Boston Alternative Energy Facility

Statement of Common Ground between Alternative Use Boston Projects Limited and RSPB

Planning Inspectorate Reference Number: EN010095

Date: 24 March 2022

Plate A1- 3 Mitigation measures proposed for the Habitat Mitigation Area

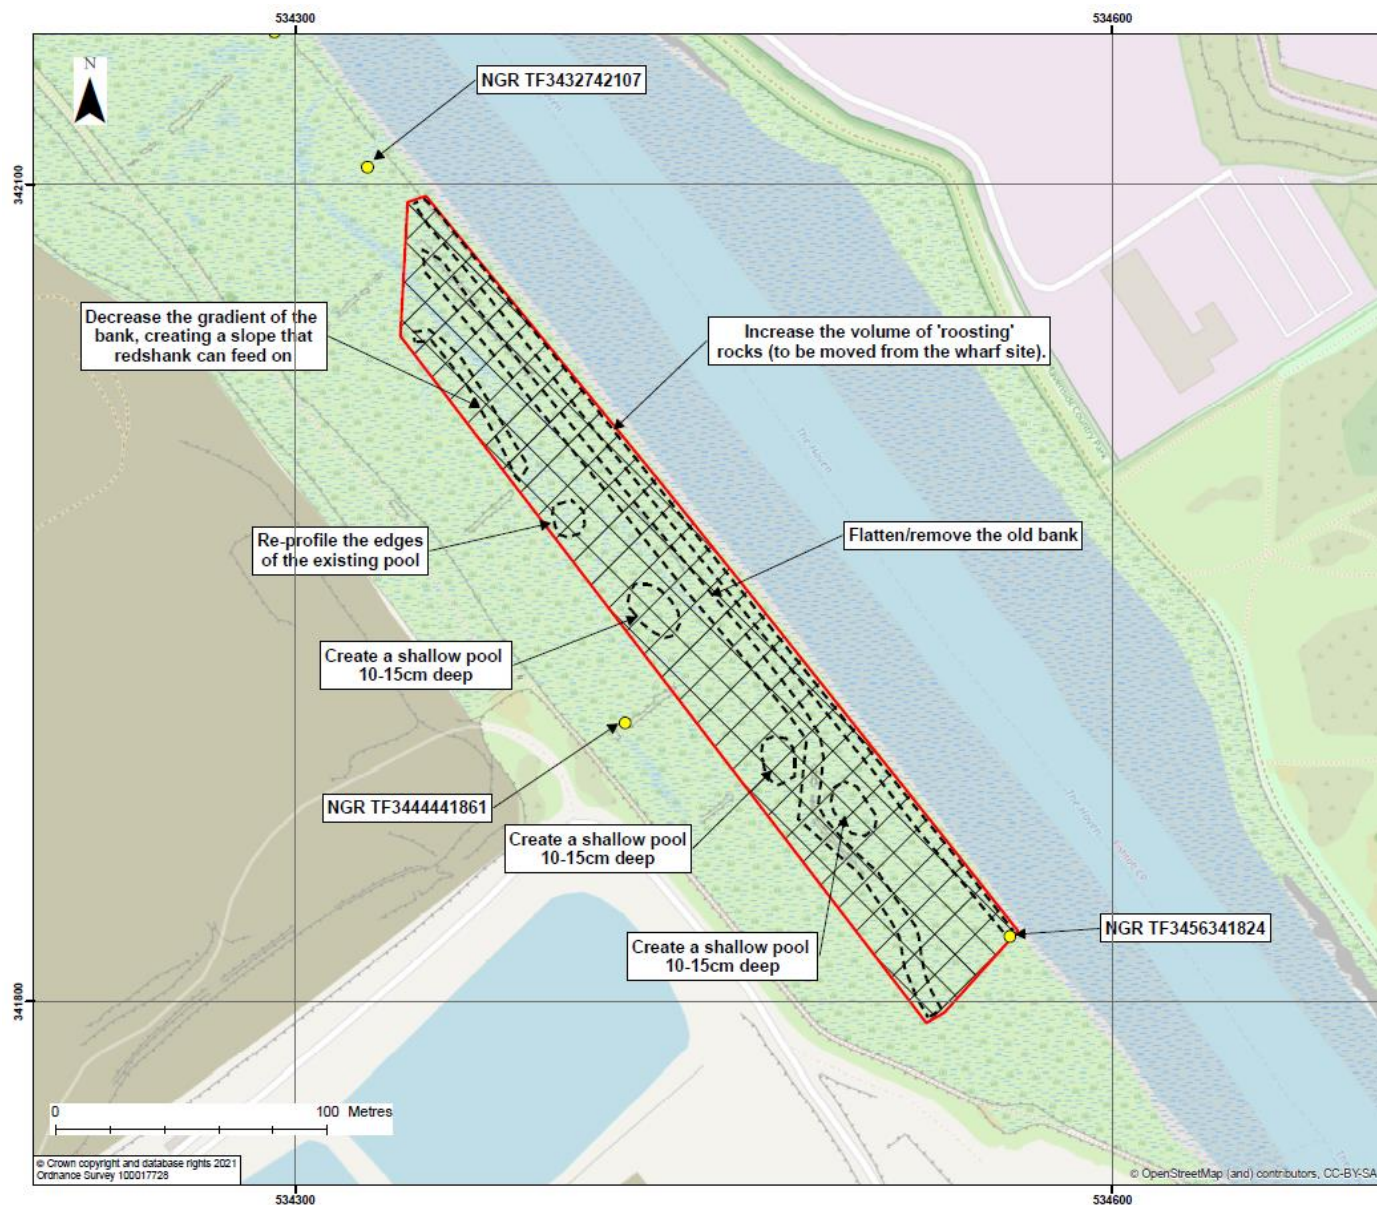
1.5	Mitigation	The proposed mitigation for the construction, operation and decommissioning phases is appropriate.	Not agreed	Not agreed	<p><u>The RSPB's Position</u> Disagreement over the phrase 'Habitat Mitigation Area'. We continue to have serious concerns about the effectiveness of the measures proposed as "mitigation". We consider the lost roost and foraging habitat should more properly be considered as part</p>

SoCG Reference	Topic	Matter	RSPB's Comment	AUBP's Position	Notes
					<p>of the compensation package set out in the Applicant's derogation case rather than as mitigation given the continued uncertainties regarding its effectiveness. Our full position on this has been outlined in our response to Written Question Q3.3.1.34 (REP7-030).</p> <p><u>The Applicant's Position</u> The applicant is of the view that this term is correct.</p> <p>See paragraph 1.4.3 for further information. The Applicant considers that mitigation set out in the application is appropriate and sufficient to the potential effect identified.</p>
